Subject: RE: Merry England, Dappers Lane, Angmering - Ref: A/142/16/OUT

Further to your email to Juan below, I have looked at this NMA this morning and I'm afraid that we will be refusing it.

DRAWING TITLE
DRAINAGE LAYOUT

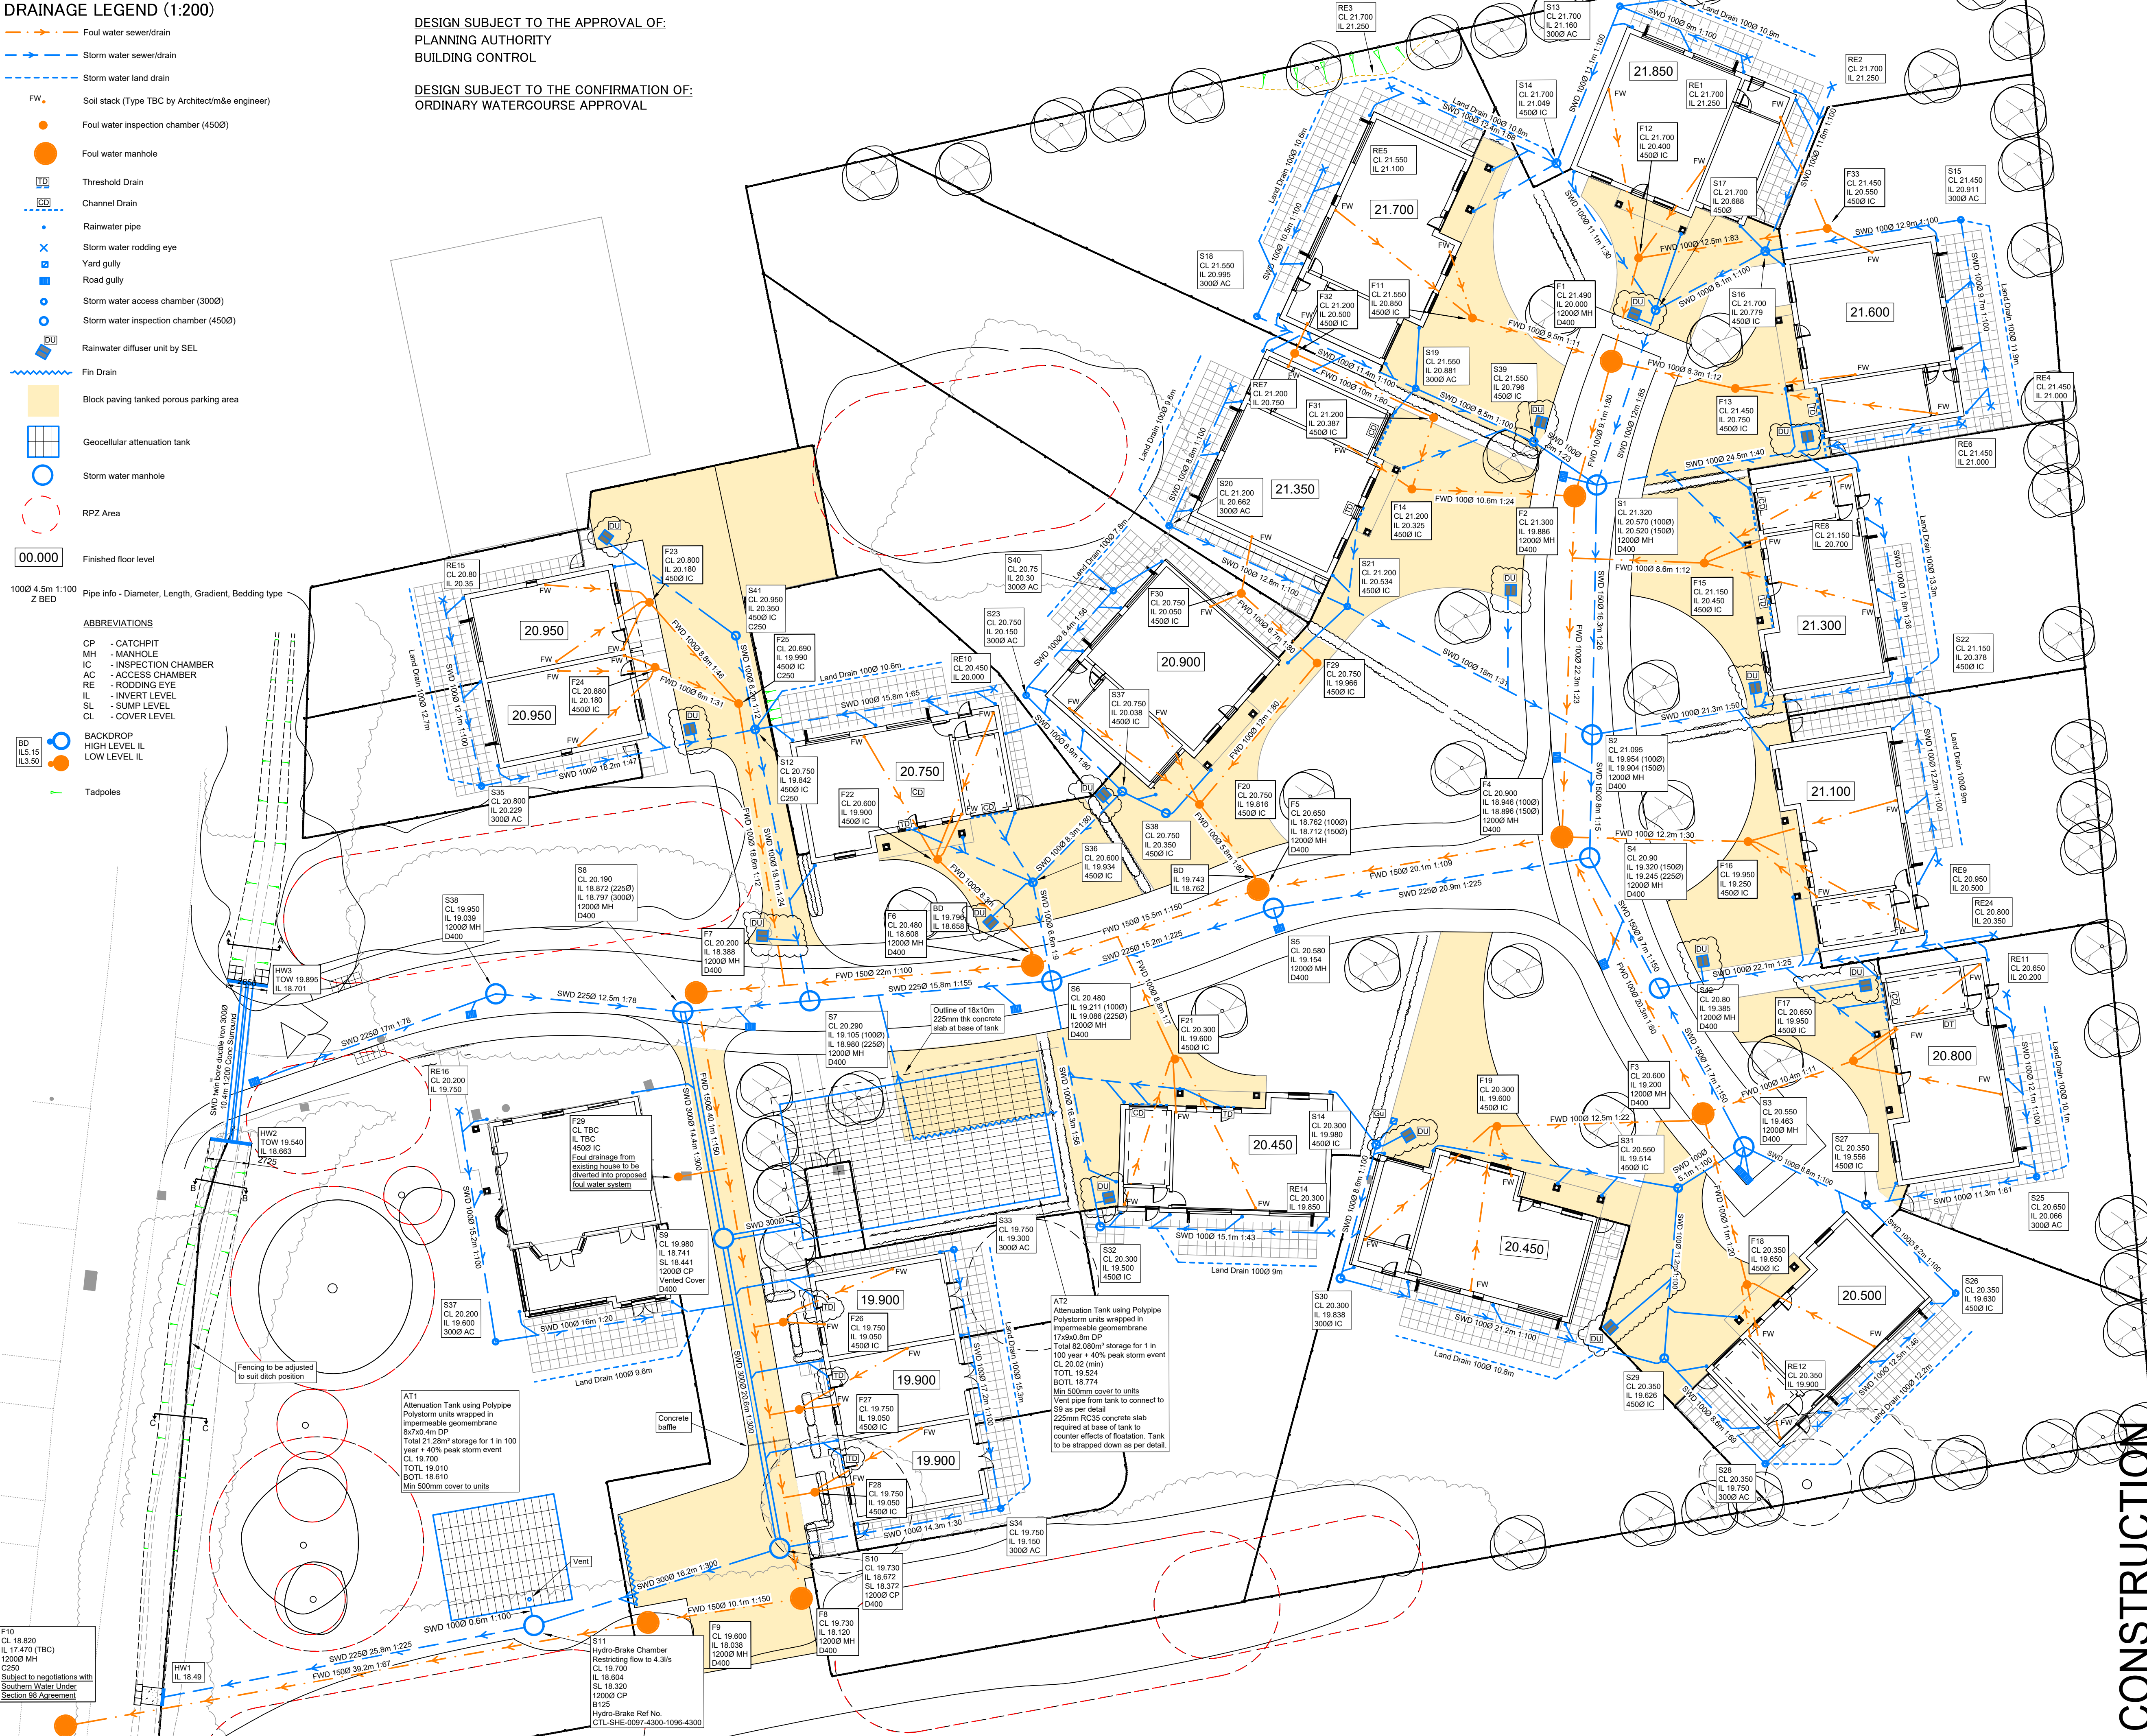
You are seeking to change hardstanding to improve drainage. Whilst I appreciate that this is intended to improve site drainage, we need to consult with our engineers on this as we would be sanctioning a change to the approved drainage plans. Our guidance set out on the website states that we can't do an NMA if it warrants consultation with other Council depts.

I refused something very similar (BR/278/19/NMA) which proposed to change the finishes to parts of the driveway/hardstanding to aid drainage and I stated in response that *we are unable to approve the changes to the hard surfacing, particularly to the driveway as these alter the details approved by BR/193/19/DOC in relation to the discharge of condition 07 and it would be necessary to consult with the Councils drainage engineers before such changes could be agreed.*

You should instead seek to re-discharge condition 4 of A/91/18/PL. You should also consider whether you need to apply for an NMA of the particular Reserved Matters permission on which hard & soft landscaping details were approved.
